RE: INTERIM AUDIT ADVICE LETTER NO. 4 - SSD 8925 MOD 7, THE NEW SYDNEY FISH MARKET

Ramboll Australia Pty Ltd
Level 3, 100 Pacific Highway
PO Box 560
North Sydney NSW 2060

This fourth Interim Audit Advice Letter (**IAA #4**) has been prepared to address new requirements for Condition B93 which requires audit review of the letter 'Re: *Sediment Capping – Environmental Assessment, New Sydney Fish Market*', 15 February 2022, Senversa Pty Ltd (Senvessa) (**the Capping Methodology Letter**).

Status	FOR INFORMATION (NOT FOR CONSTRUCTION)	AO
Drawing No.	ATL-CV-SKT-00042	Issue 20-819

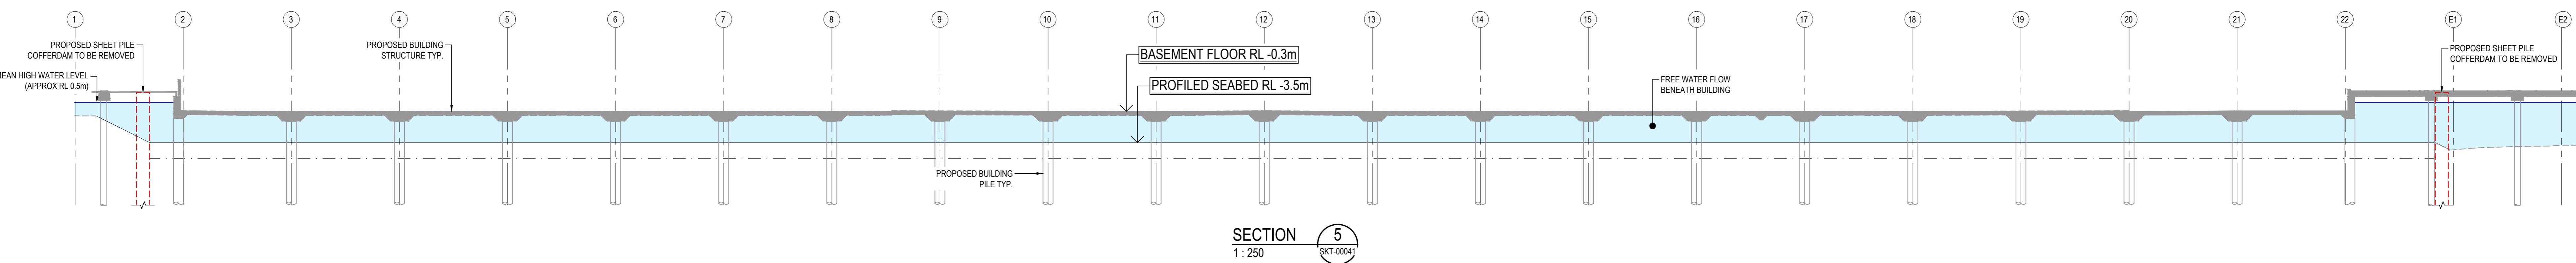
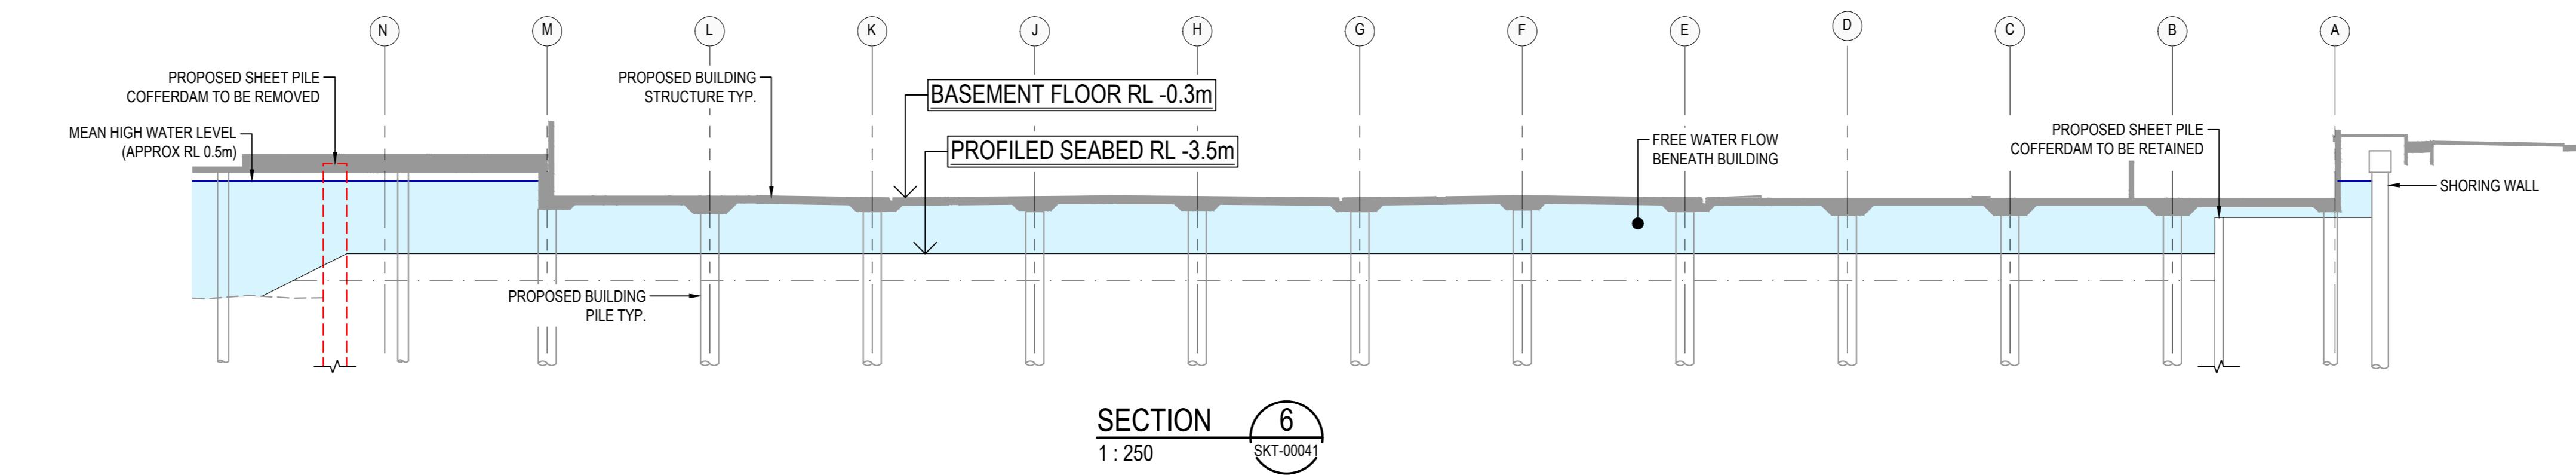
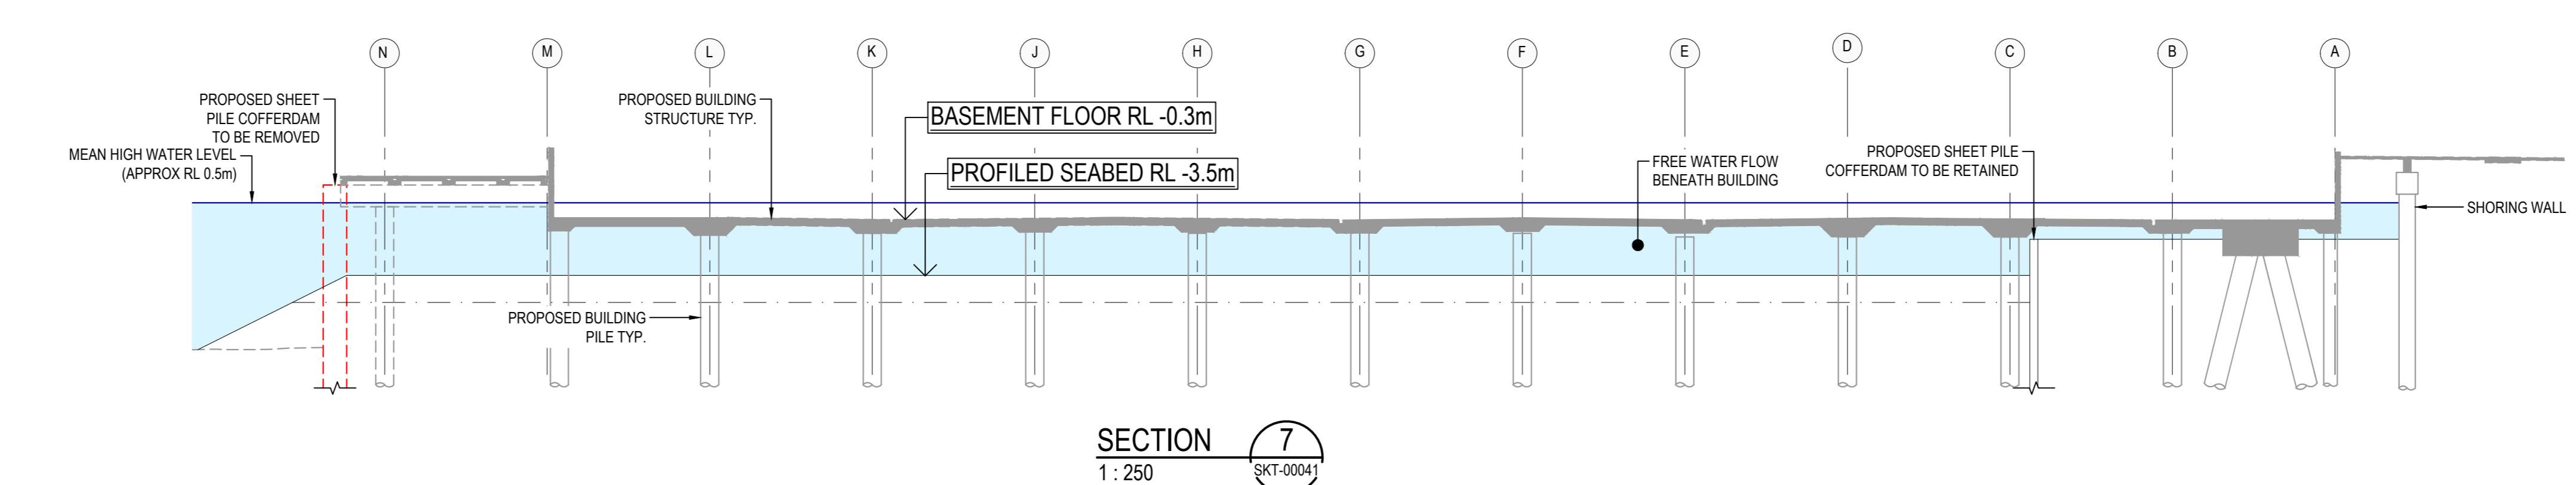
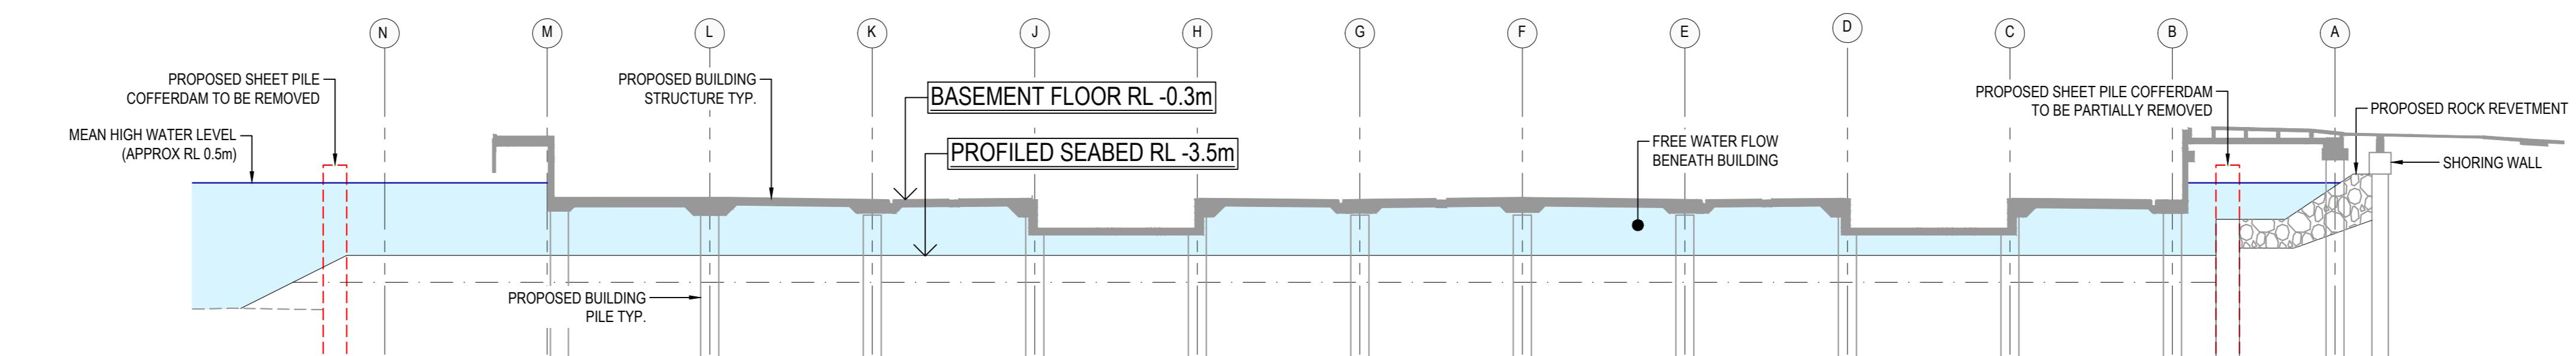
At completion, the level of the sand layers will be -3.9 AHD, which is 200 mm above the dewater level. Following dewatering, the remaining capping layer of crushed stone will be installed via land-based machinery building the sediment level up to -3.5 AHD, which is approximately 2.93 m below mean low water tide (-0.57 AHD).

Based on this methodology, the potential acid sulfate soil (PASS) sediments will remain submerged beneath 1 m of water and sand after dewatering (with 200 mm of sand and 400 mm of crushed stone above the dewater level during works). In total the cap will be 1.6 m thick.

A cross section of the proposed cap and relative water level is shown on **Attachment 3**.

Given that the sediments are to remain water-logged, the proposed works are not expected to result in significant oxidation. Therefore, subject to appropriate validation of the imported VENM in accordance with the Revised RAP, I am of the opinion that the proposed capping is acceptable.
